From: Samantha Allen
Sent: 16 August 2018 10:07
To: Planning Scanning
Subject: FW: M/83/18/HH - Holly Cottage, Yapton
Attachments: OS site plan highways visibility splays.pdf

Comments as requested addressing the WSCC highway comments raised regarding the above planning application, dated 01/08/18.

Visibility

DRAWING
**SITE PLAN
LOCATION PLAN**
DRAWING No
264/01

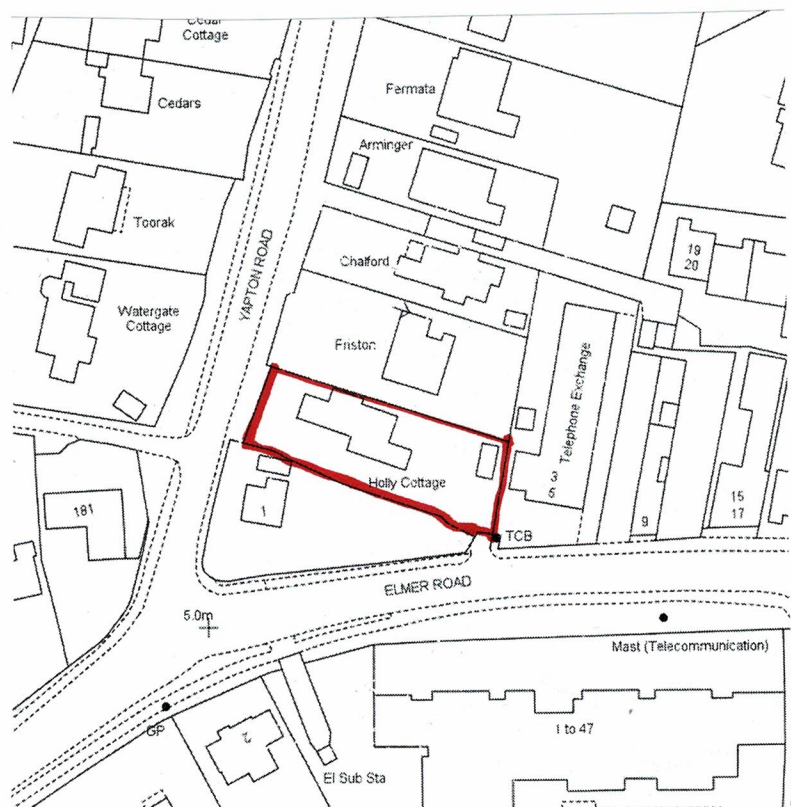
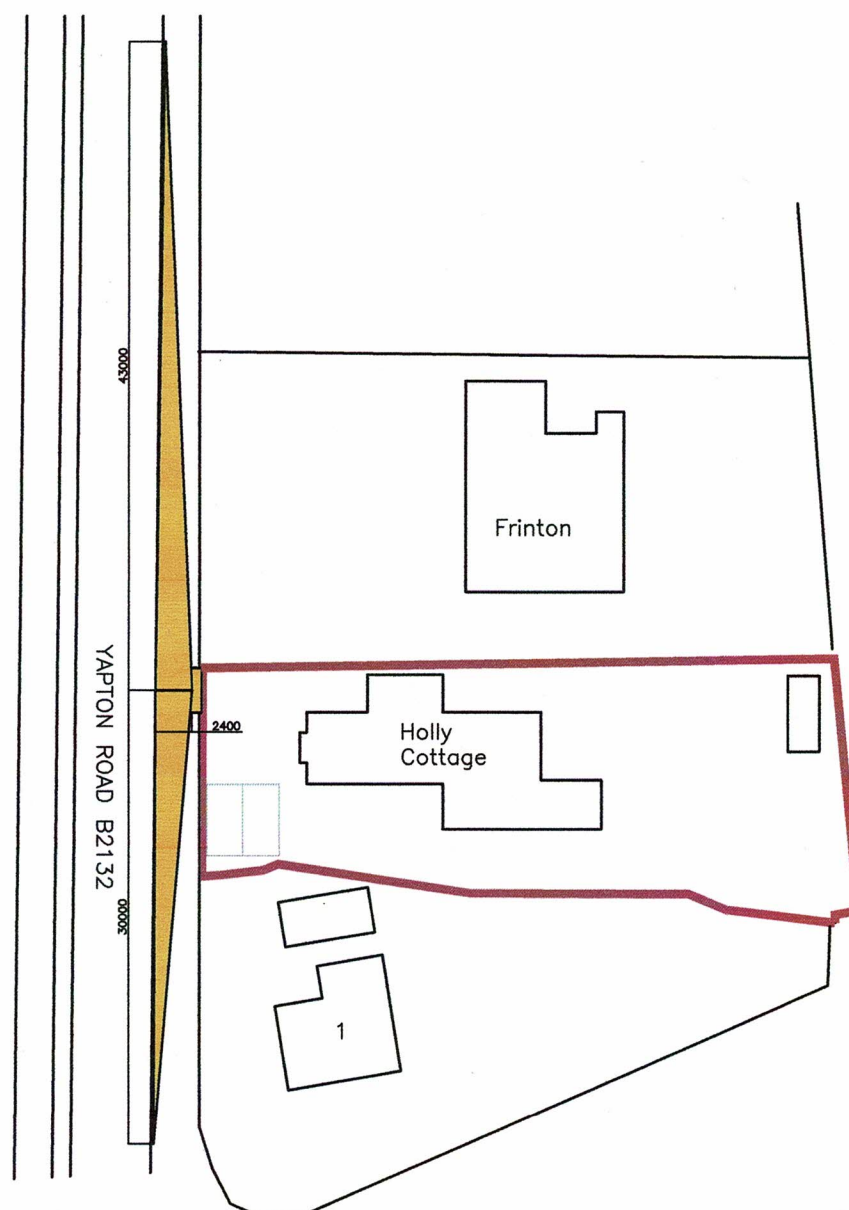
Clarification of requirement for secondary access to site.

The provision of the vehicular access off Yapton Road will provide parking adjacent to the property's front door, significantly reducing the current walking/carrying distances in comparison with the proposed access arrangements. The proposed access will not only assist and ease the burdens for the Owner, but her visitors too.

The reflective highway posts positioned within the eastern verge of Yapton Road currently prevent/discourage on street parking in the vicinity of Holly Cottage. The proposed secondary access would not result in a loss of on street

parking provision for neighbouring residents, as the existing highway layout and street furniture currently effectively prevent/discourage on street parking where the proposed access would be located.

Holly Cottage, Yapton Road, Middleton-on-sea, Bognor Regis

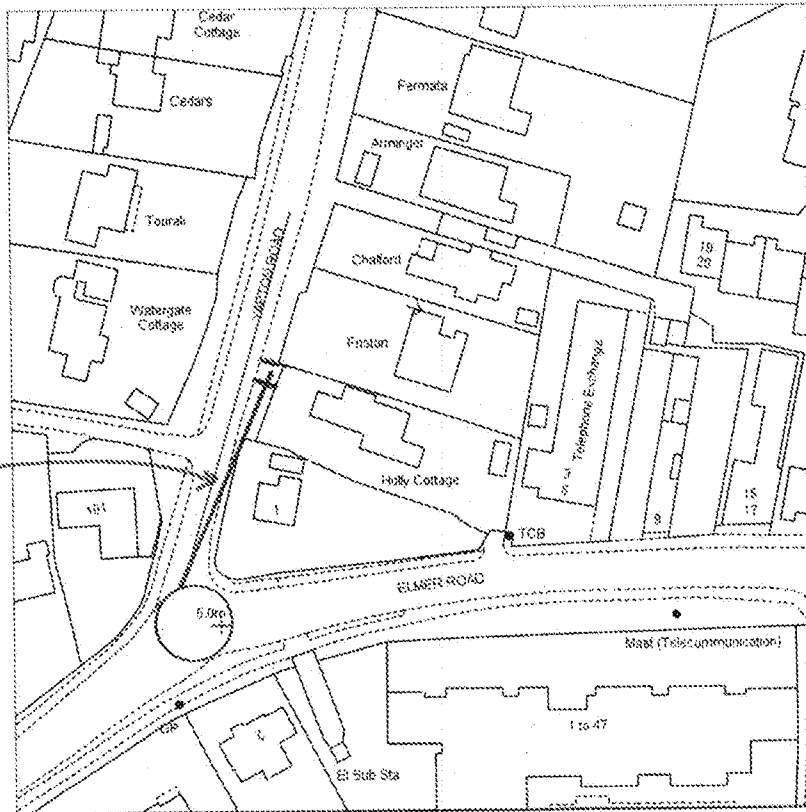
We note that WSCC are seeking a junction visibility splay of 2.4 x 43m in line with MfS for a highway with a speed limit of 30mph, and that they are content that the northern junction visibility splay can be achieved within the existing highway boundary.

We would highlight that MfS2 permits the 'y' distance to be measured to the middle of the road (ie highway centreline) for the left hand visibility splay, if it is '*unlikely that vehicles approaching from the left on the main arm will cross the centreline of the main arm.*' It is our view that vehicles that have entered Yapton Road from either Elmer Road or Middleton Road have just negotiated a mini roundabout junction and thus will be within their designated lane, and thus deemed unlikely to cross the centreline of the main arm in this location. Furthermore, the vehicle speeds travelling north along Yapton Road from the mini roundabout are likely to be lower than 30mph immediately north of the junction, given the tight turning manoeuvres required to negotiate the mini roundabout junction.

On this basis it is considered that a junction visibility splay to the south of the new vehicular access to Holly Cottage should be measured to the centreline of Yapton Road. However, it is considered that 43m would take the visibility past the roundabout junction, and thus the splay should be taken to Yapton Road's centreline intersection with the outer diameter of the roundabout, resulting in a 'y' dim of approx. 36-40m.

It is considered that this junction visibility is clearly achievable from site inspections, and trust that your WSCC mapping concurs with this view.

It is acknowledged that highway verge along the eastern side of Yapton Road tapers in from Holly Cottage to the south towards Elmer Road. However, the proposed visibility splay outlined above is not affected by this occurrence. However, existing vegetation between Holly Cottage and Elmer Road along the eastern verge appears to have grown in recent years and this could be addressed to the satisfaction of the Highway Inspector through a planning condition should you be minded to concur with our above views, in order to improve/maintain highway safety.
